# STERLING RANCH - VOLLMER ROAD

### STREET IMPROVEMENT PLAN

#### SEPTEMBER 2020

**Engineering Review**  
11/01/2020 9:27:40 PM  
dsdrice  
JeffRice@elpaso.co.gov  
(719) 520-7877  
EPC Planning & Community Development Department

**STERLING RANCH -
 STERLING RANCH ROAD
 STREET SECTIONS**

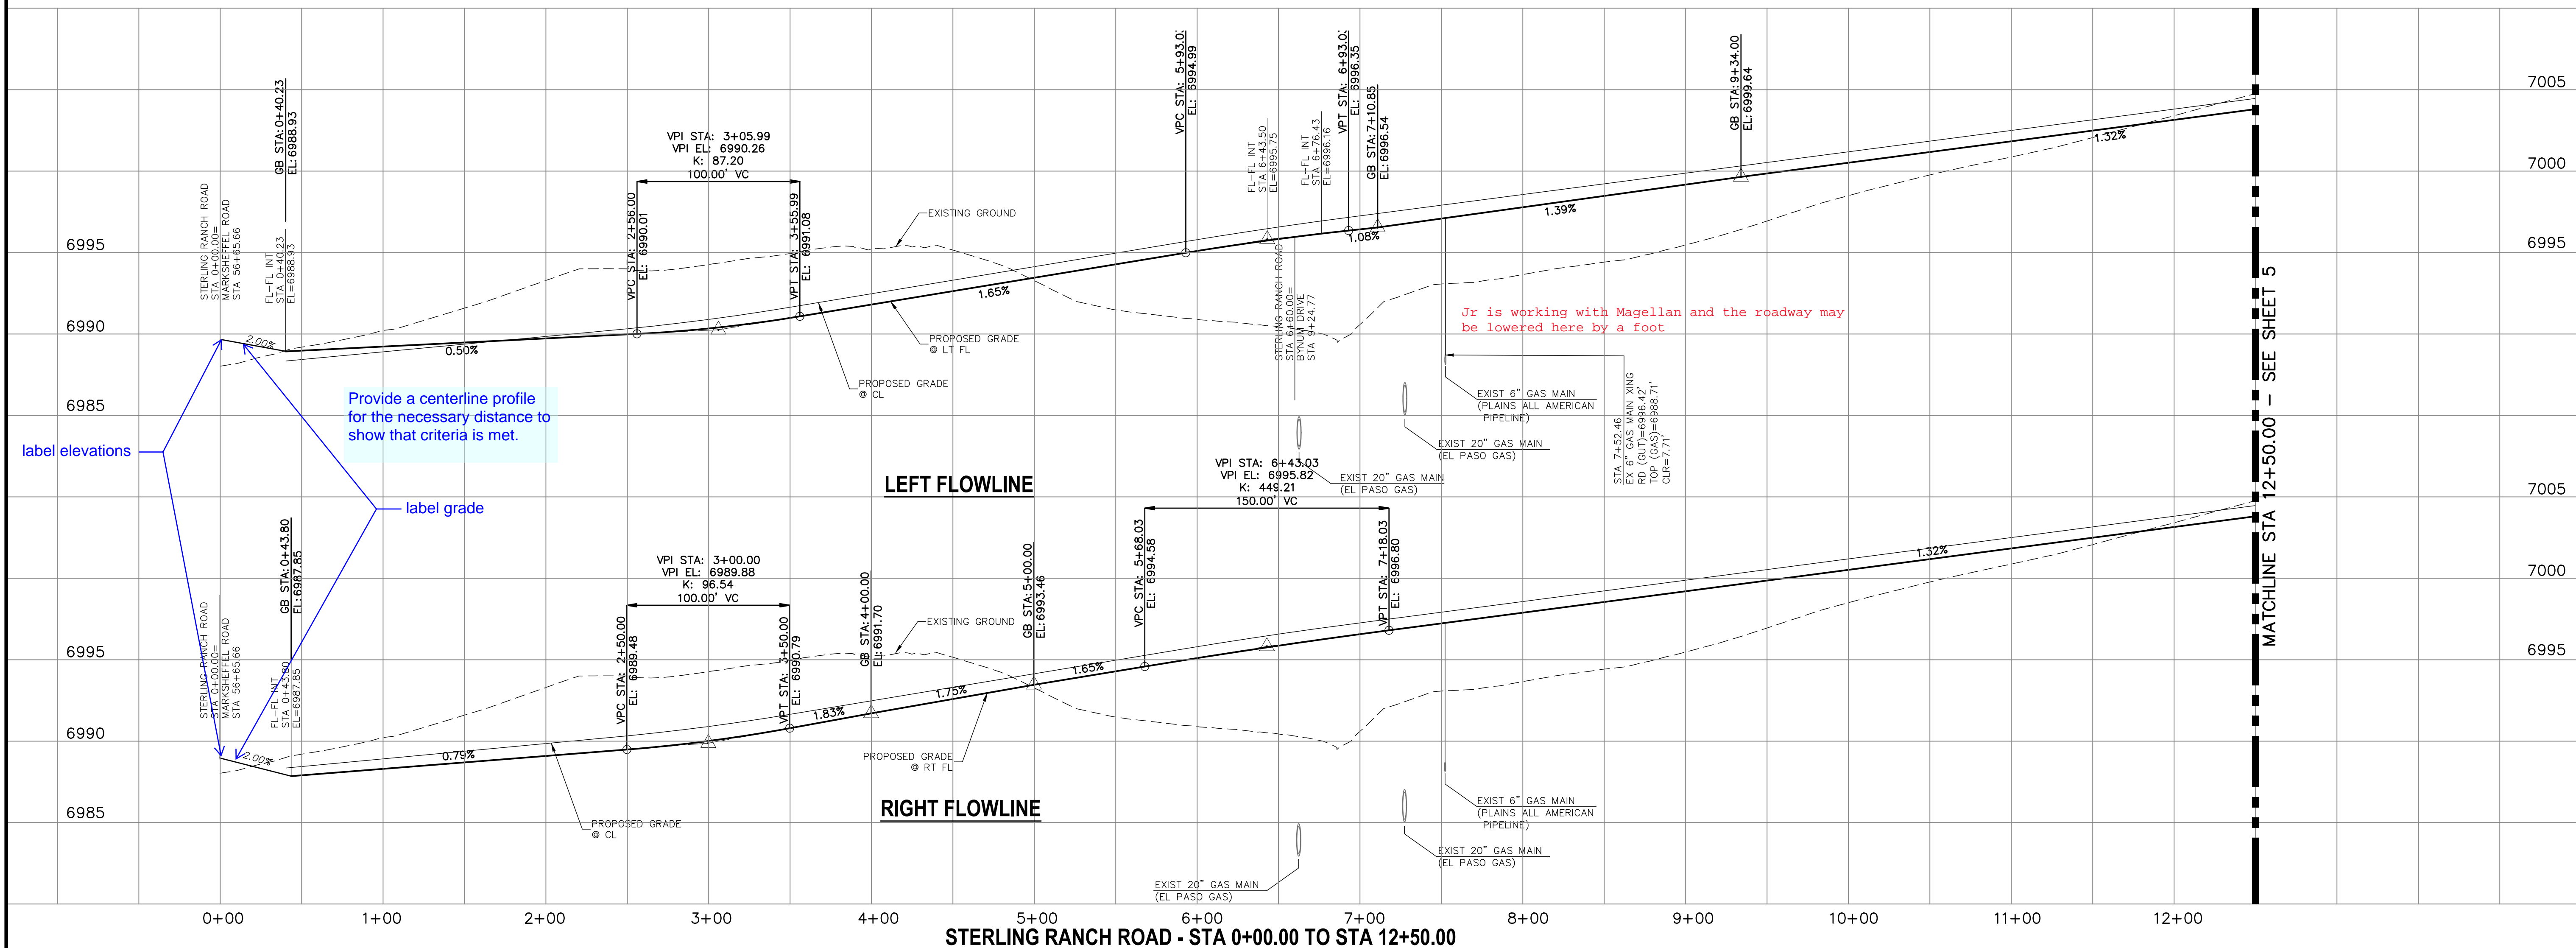
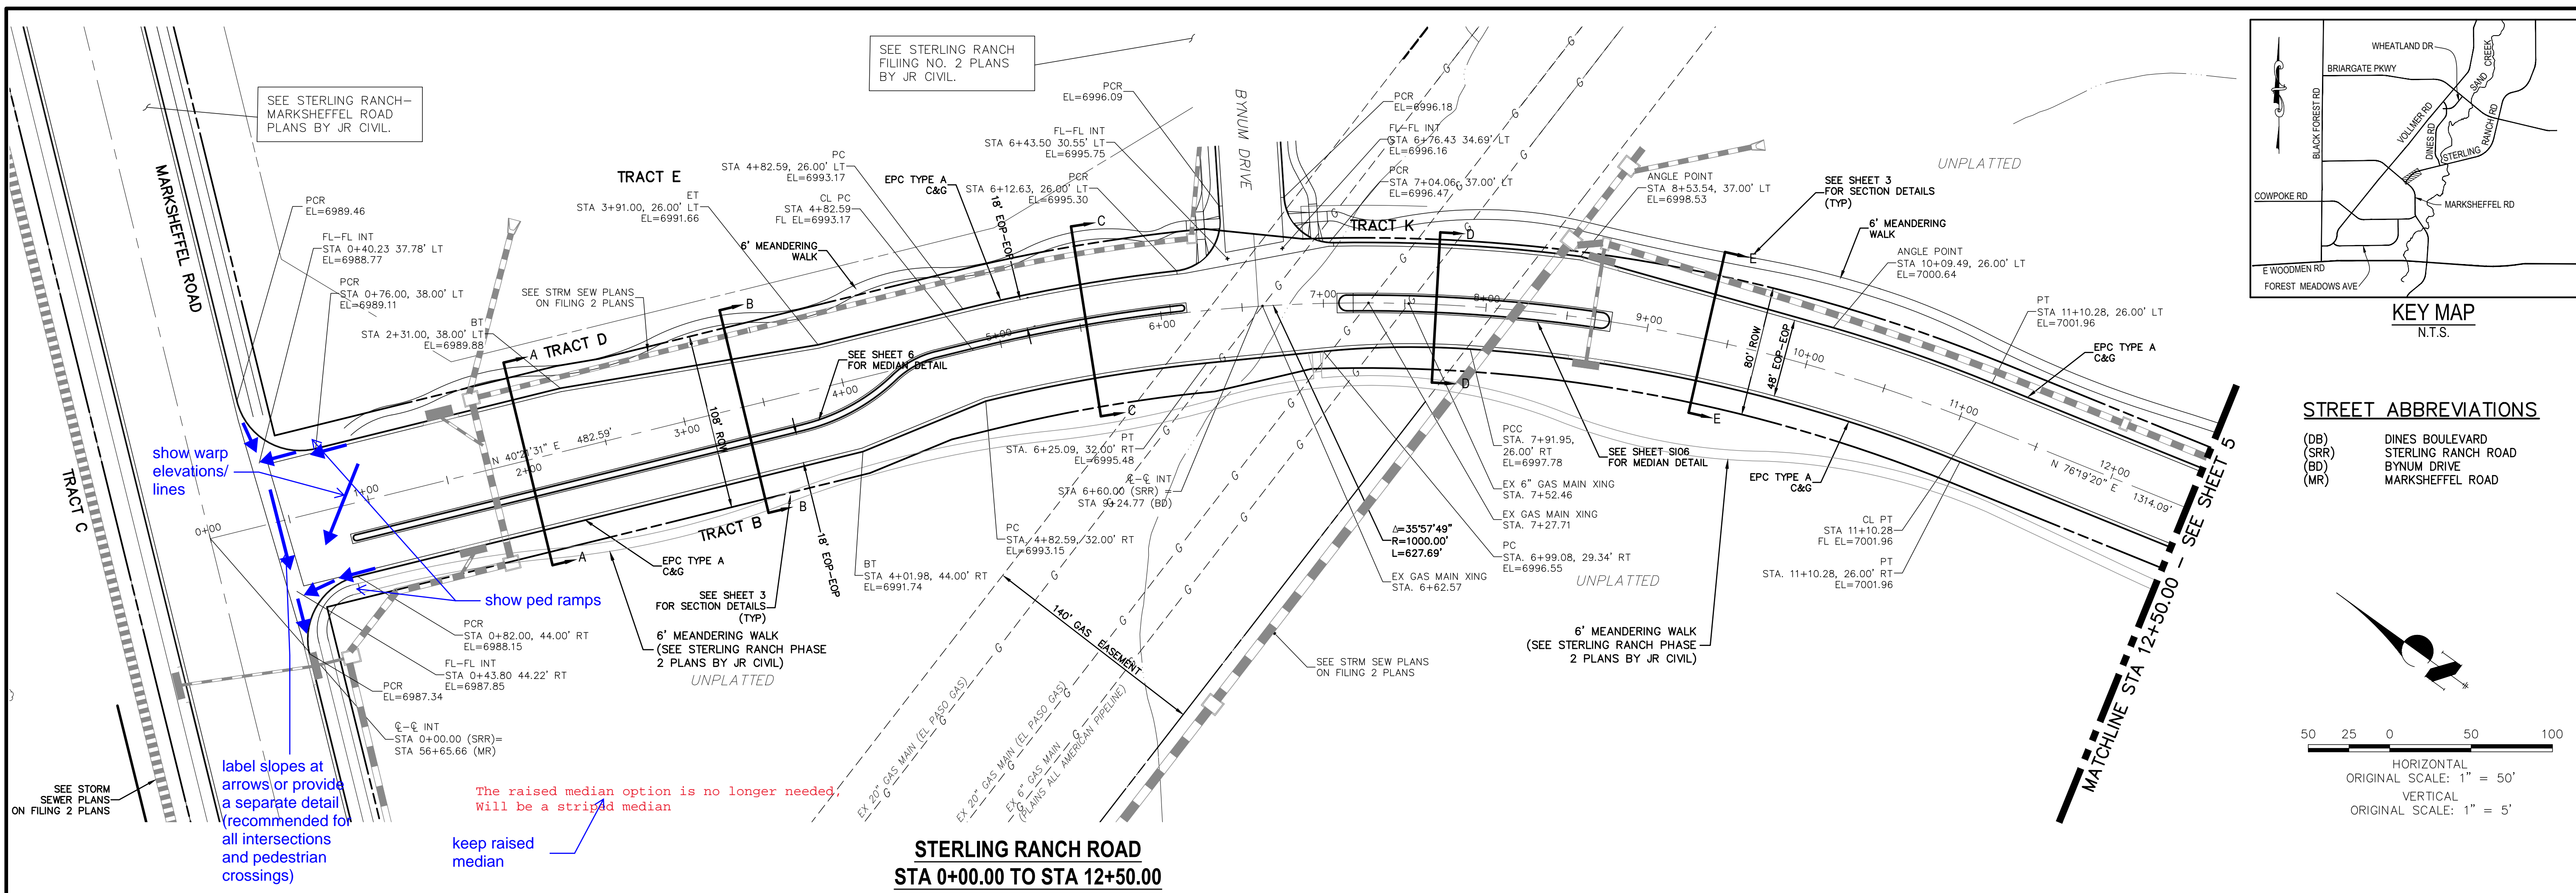
Provide typical sections for the segments.
